Subject: FW: CBRK response 1 July 2019 - ECQ Mod 4
Attachments: 20190701_125711.pdf

From: Tim Rogers <tim.rogers@cbrk.com.au>
Sent: Monday, 1 July 2019 12:57 PM
To: Mark Cleveland <Mark.Cleveland@frasersproperty.com.au>
Subject: CBRK response 1 July 2019 - ECQ Mod 4

As requested we have reviewed the RMS letter (dated 1 July 2019) and DPE request to comment on whether the RMS requirement to have entry only to Lot 2 to the roundabout would provide suitable access to Lot 2.

DA38 P 1

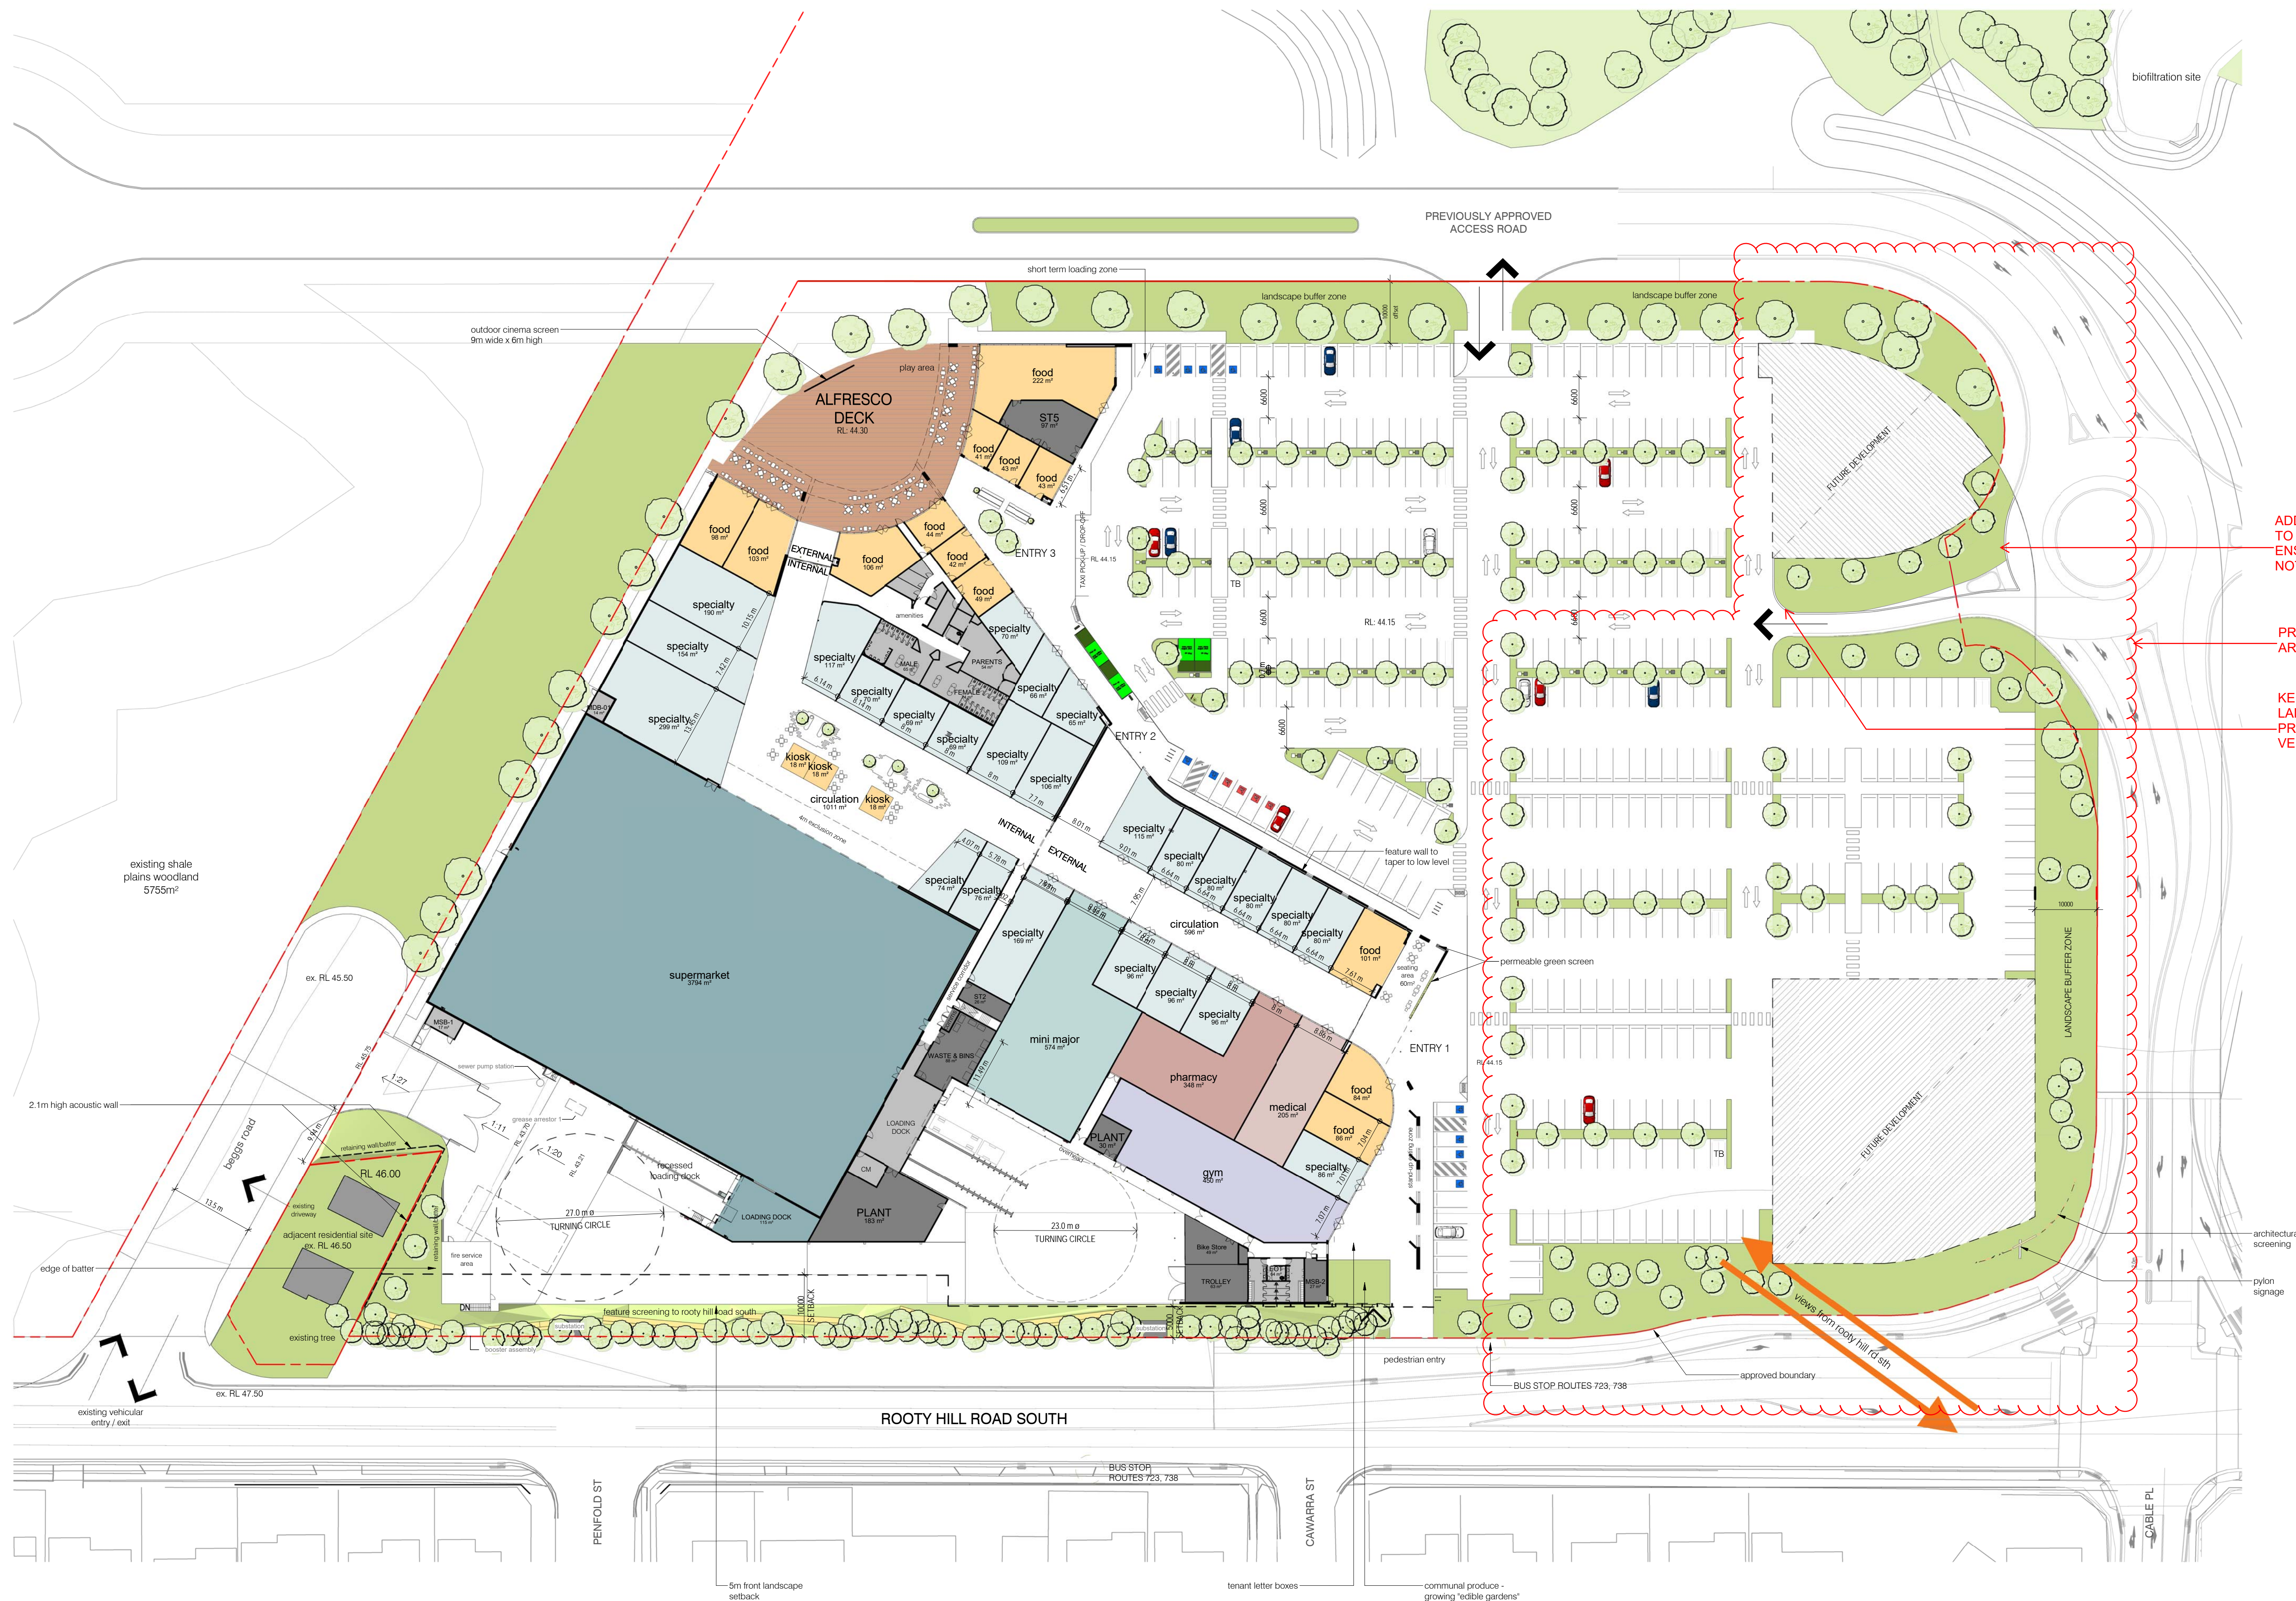
Our review has found that with entry only to Lot 2 from the roundabout, vehicles exiting Lot 2 would use the driveway to the Spine Road located on the eastern boundary of Lot 2. While this does not provide as convenient egress from Lot 2 as a connection to the roundabout, this driveway would provide the necessary capacity to cater for vehicles exiting Lot 2 during each stage of development as set out the concept approval.

Also as requested we have marked up a plan showing the required changes to the roundabout design to limit the connection to Lot 2 to entry only.
